**Consultation Response from KC,
Highways Development Management**

2024/93377 Land adj, 196, Wakefield Road, Earlsheaton, Dewsbury, WF12 8AH

Discharge of details reserved by conditions 6 (footpath), 8 (bin storage), 9 (drainage), 10 (FRA), 14 (ecology), 19 (construction management plan) on previous permission 2023/93097 for erection of 5 dwellings (class C3) and ancillary office accommodation, formation of associated access, car parking and landscaping

Date Responded: 28-1-2025.

PROPOSED KERB CONSTRUCTION LAYOUT
AND EXTERNAL WORKS LAYOUT
(SCALE 1/100)

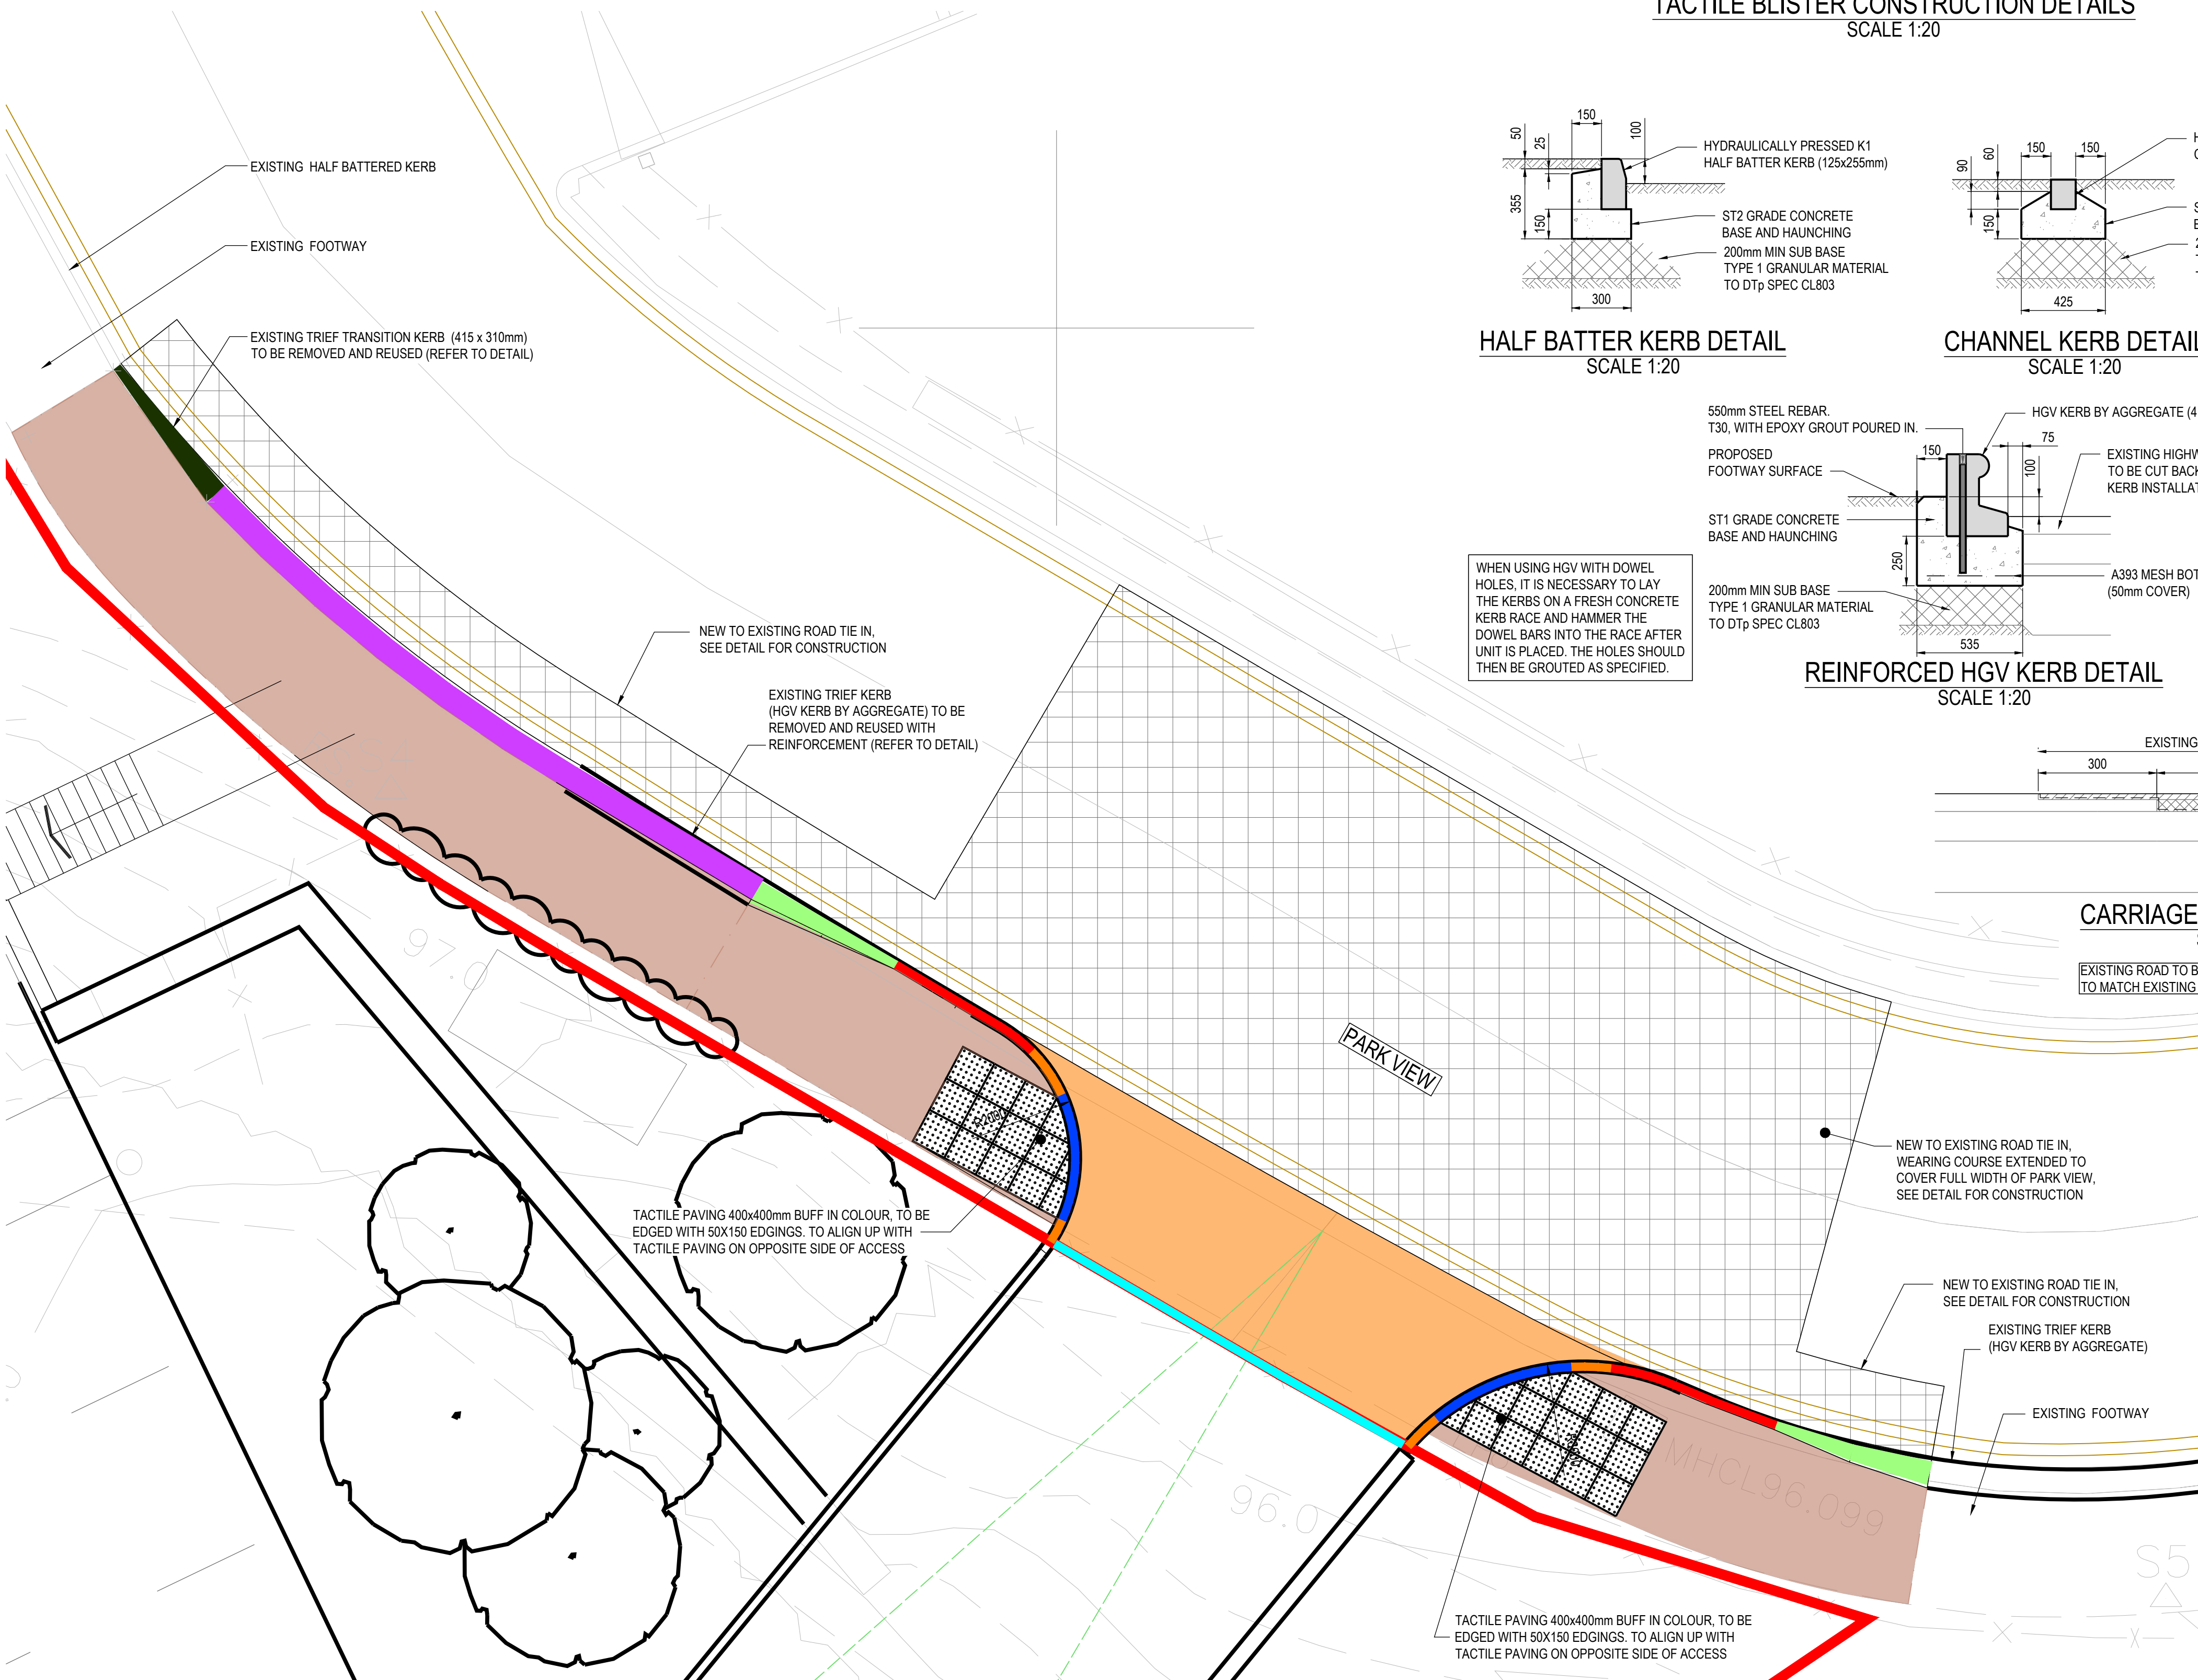
The Highways Development Management consultation response dated 11th December 2023 was as follows, *“There are raised kerbs to the frontage of the proposed development to provide vehicle restraint at the top of the existing access. These kerbs will become redundant if the levels are raised to accommodate the proposed development”*.

The applicants have submitted details of a vehicular crossing which is required to gain access to the site through the raised kerbing.

To determine whether the applicant's proposals are acceptable they need to determine if the *raised* kerbing needs to be retained, otherwise the raised kerbing will need to be shown to be removed, and a new footway provided as required by the condition.

This condition should **not** therefore be discharged.
